HILLS SHOWGROUND STATION PRECINCT - PRECINCT EAST 3 ANDALUSIAN WAY - LOT 3 & 4

State Significant Design Excellence Report

Issue	Title	Date	Prepared	Checked
A	SSDA MODIFICATION	29/05/26	KC	RV

This Design Excellence Report has been prepared on behalf of Deicorp to support the detailed design development and construction of the State Significant Development Application (SSD-62802207) which forms Showground Precinct East (lot 3 and lot 4). This report is to be read in conjunction with the Architectural Statement, Design Integrity Report and Architectural drawing package.

BUILDING A- ELEVATION COMPARISON

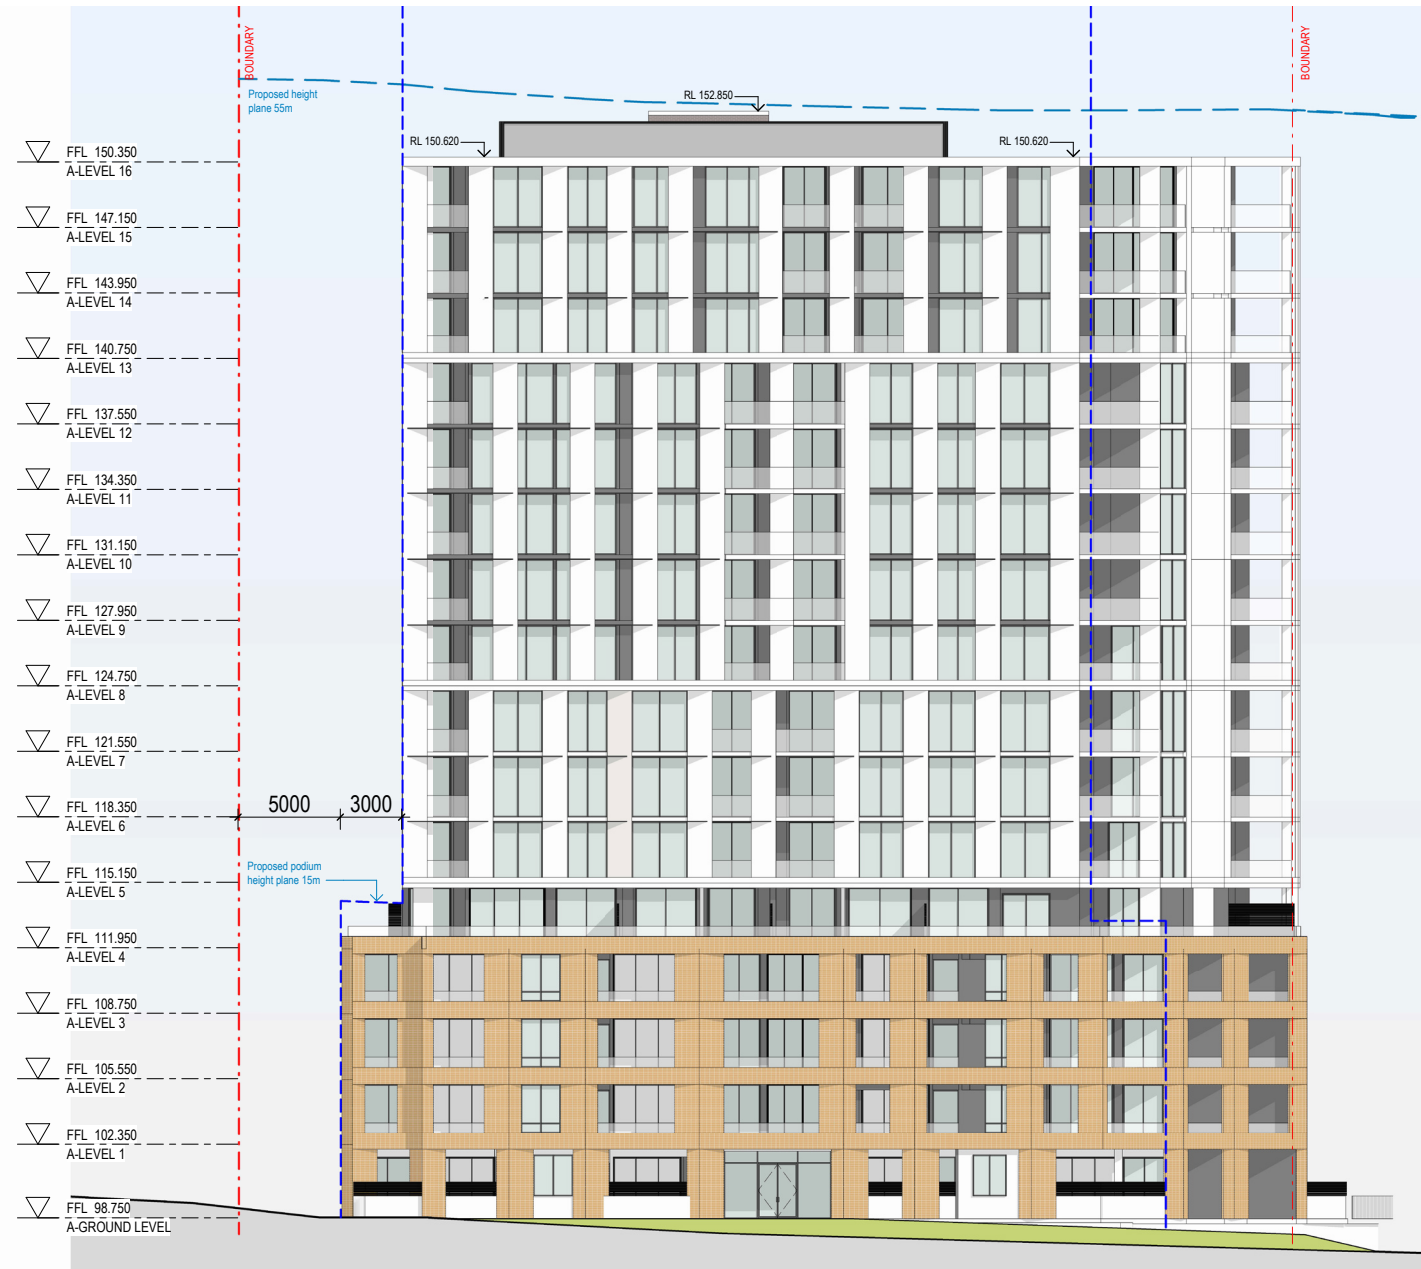
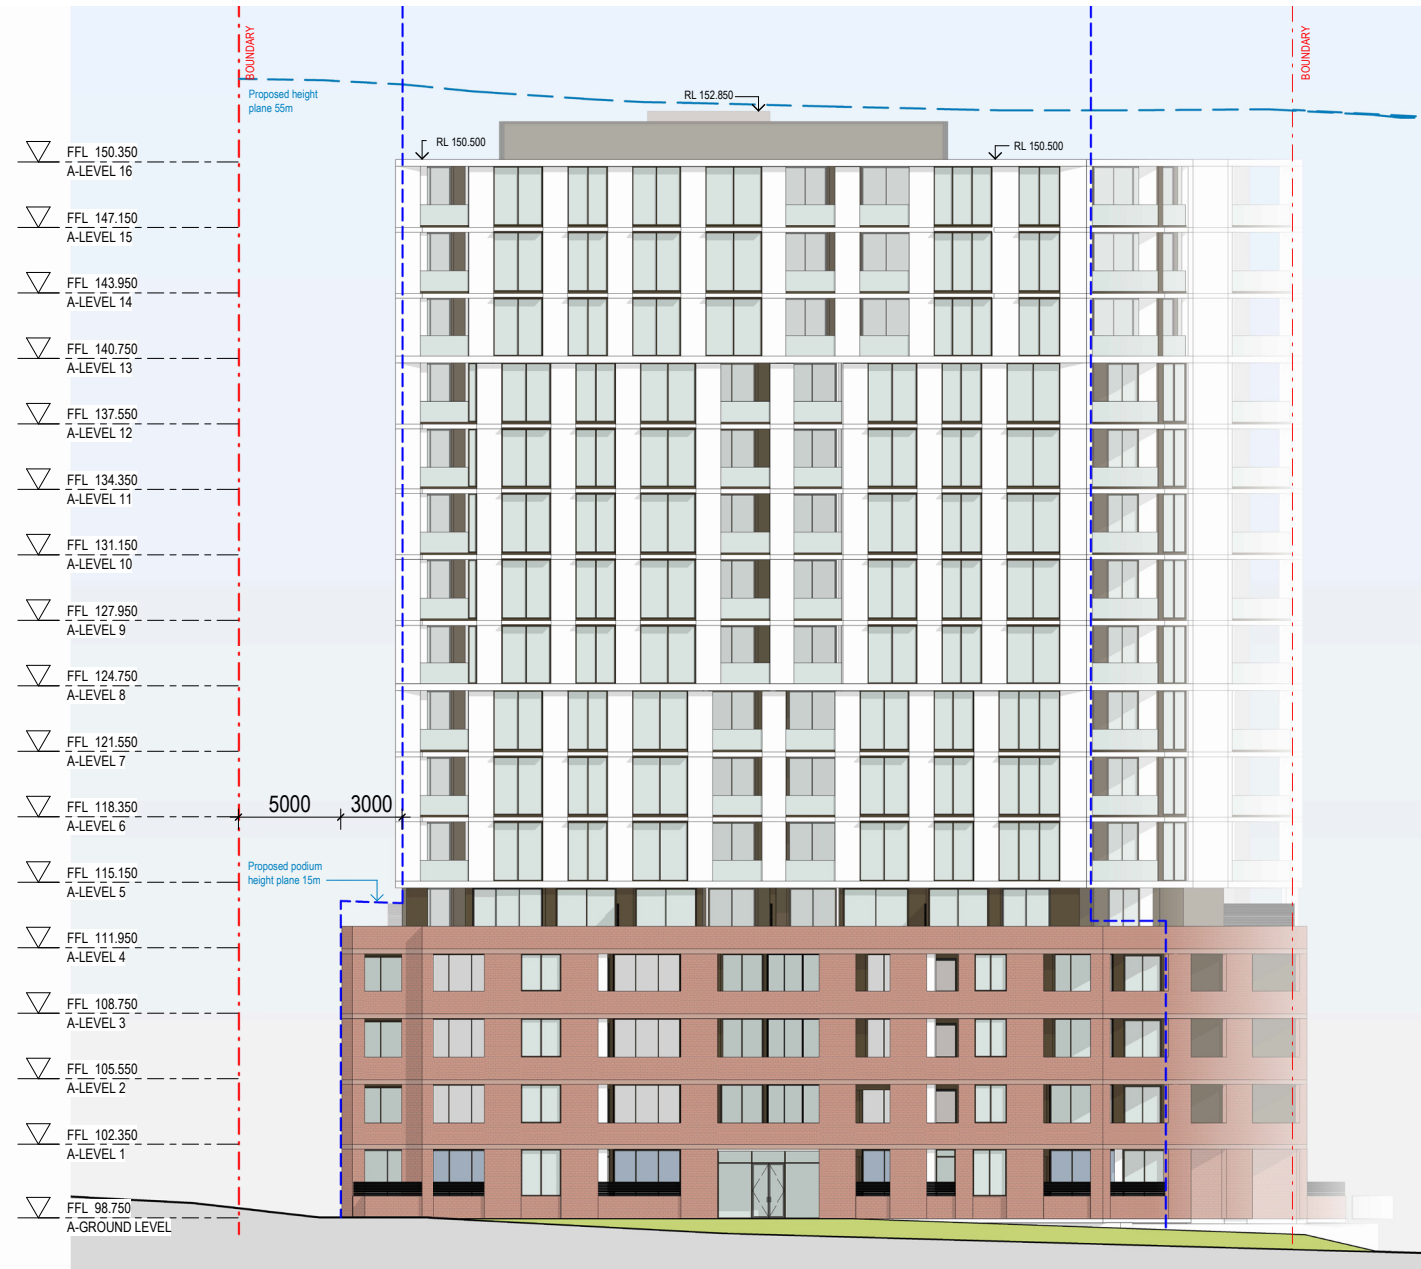
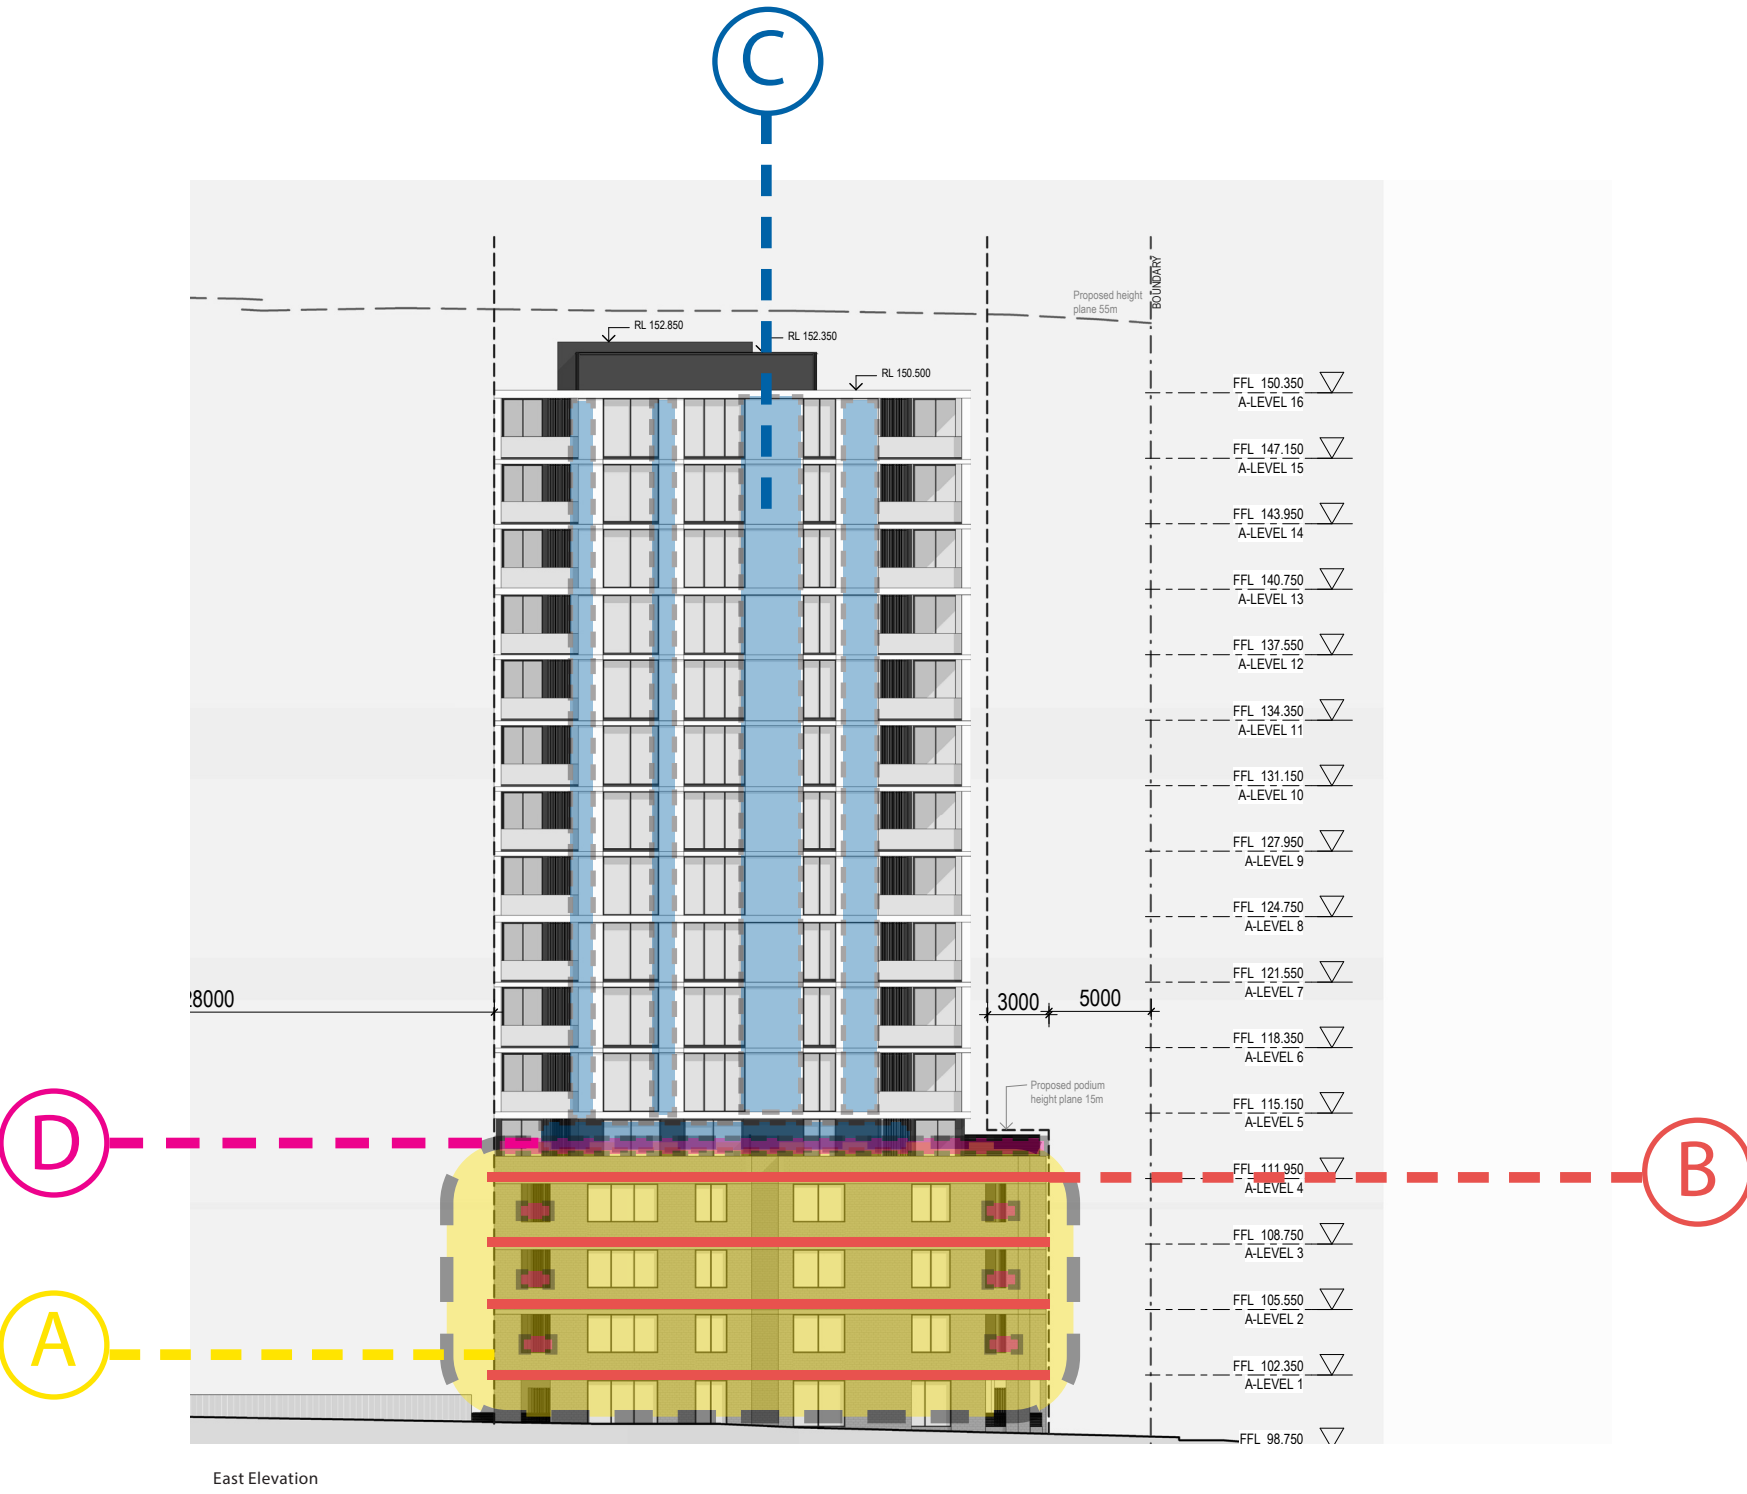
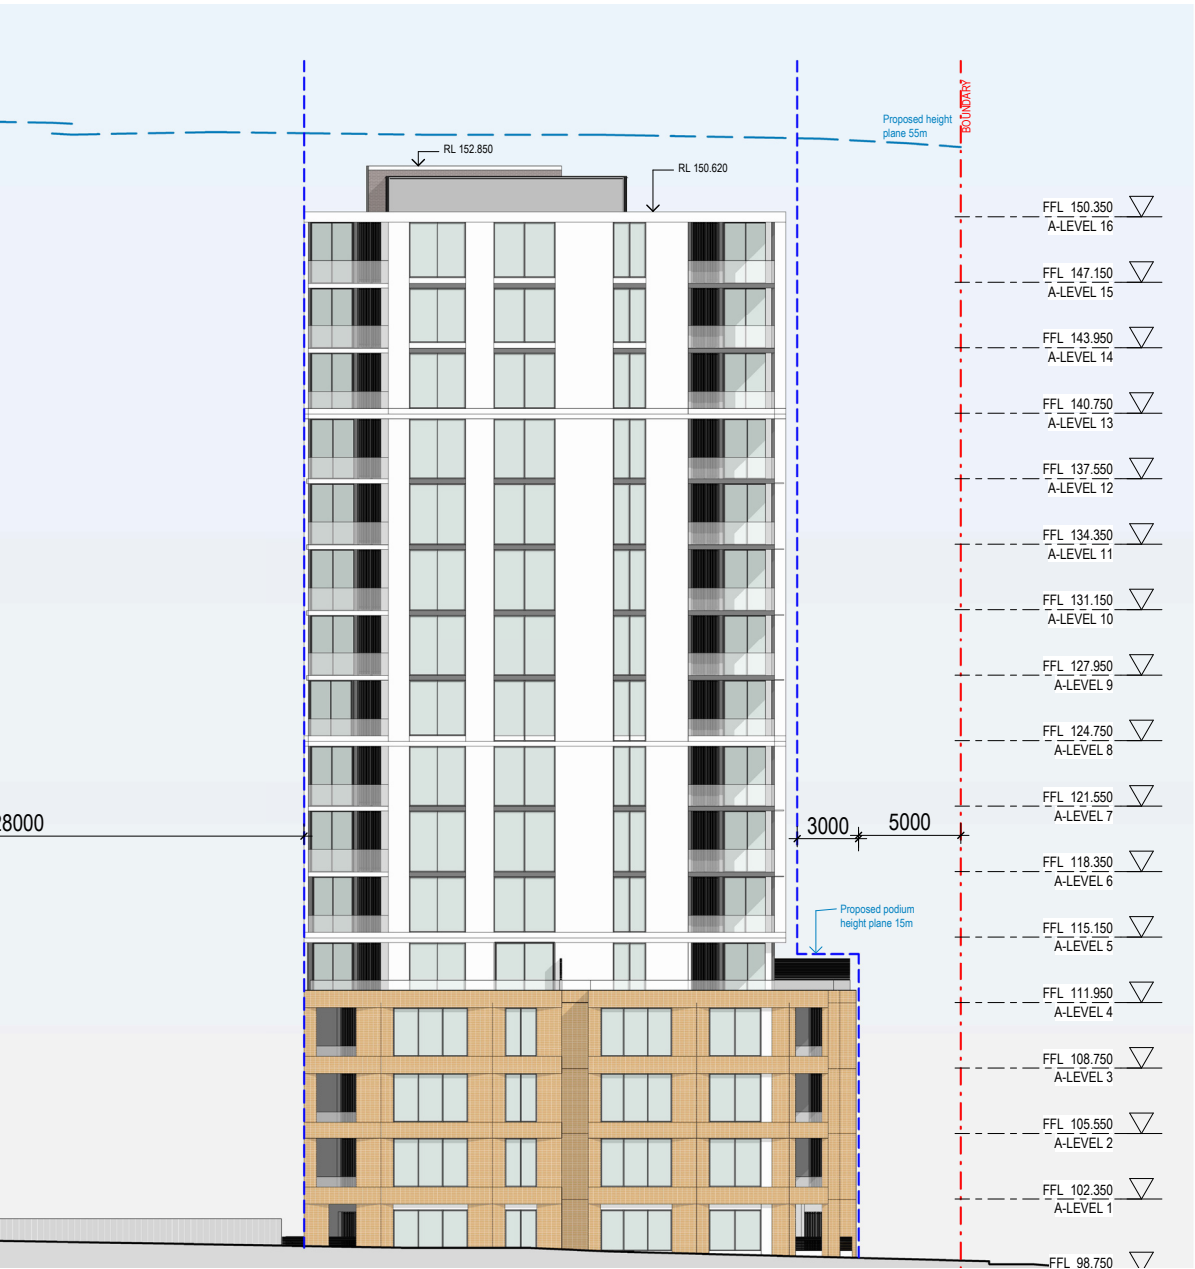
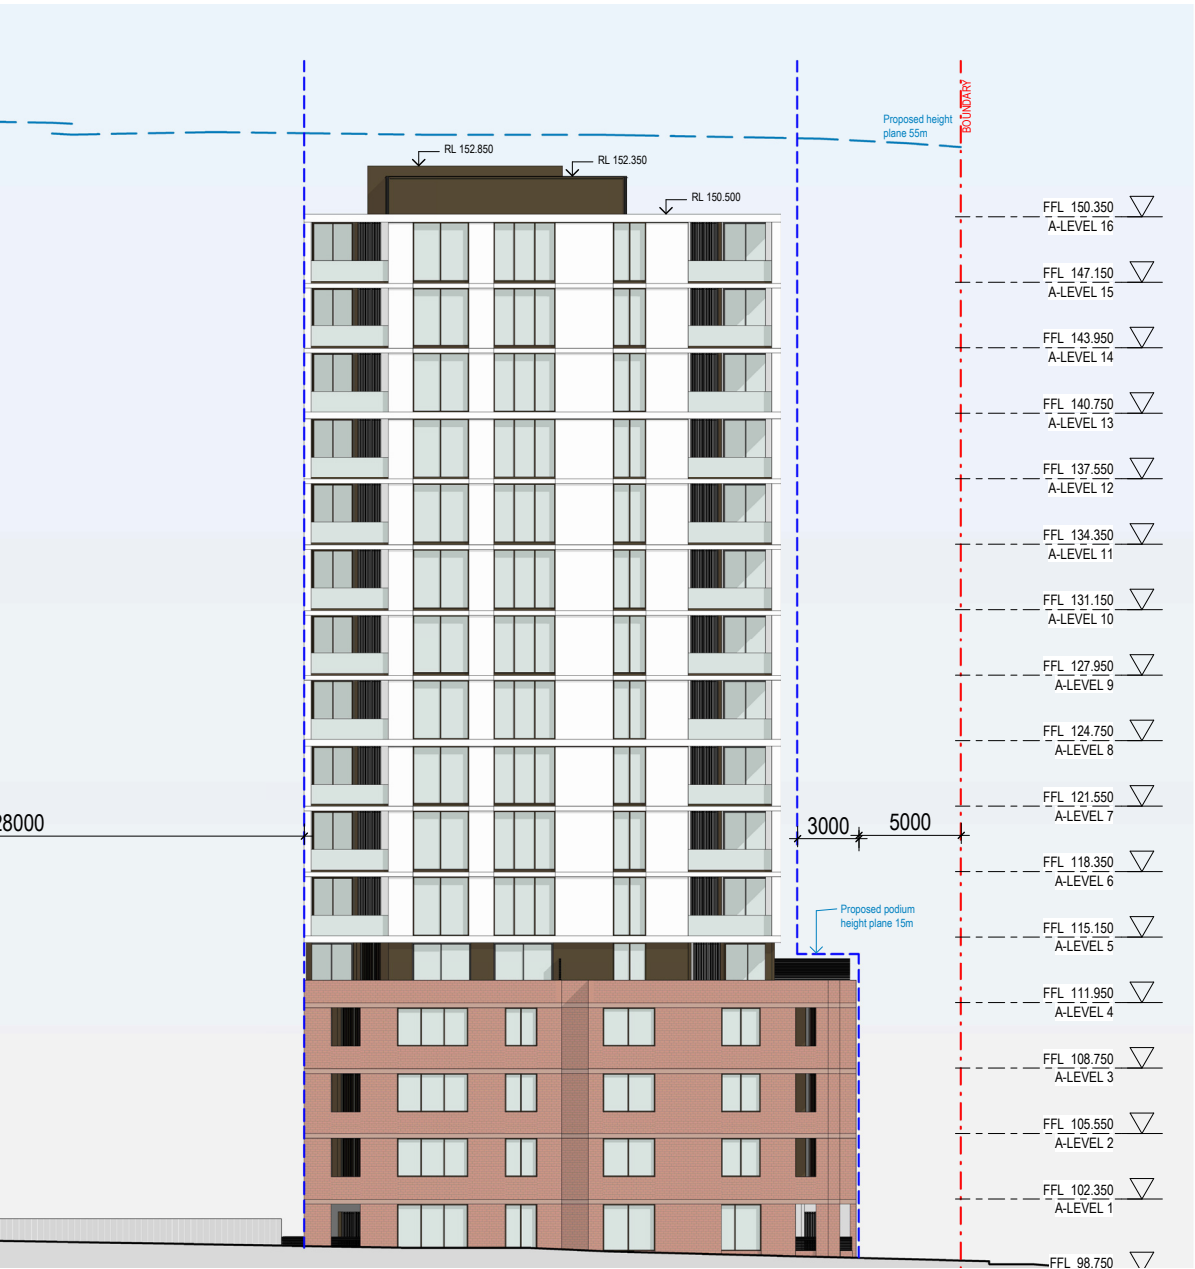
"Allow increased tolerance for the rationalisation of architectural massing within the approved envelopes. Simplify the angular massing of buildings at Lot 4, strengthening the north-west corner and reducing balcony types, specifically avoiding smaller triangular balconies. Ensure that private balconies are generous and receive sufficient solar access."

Generous balconies designed along Building A west elevation (Upper levels, although still triangular in nature due to existing site massing. All balconies are ADG compliant with greater than 70% units achieving more than 2 hours daylight to Living areas.
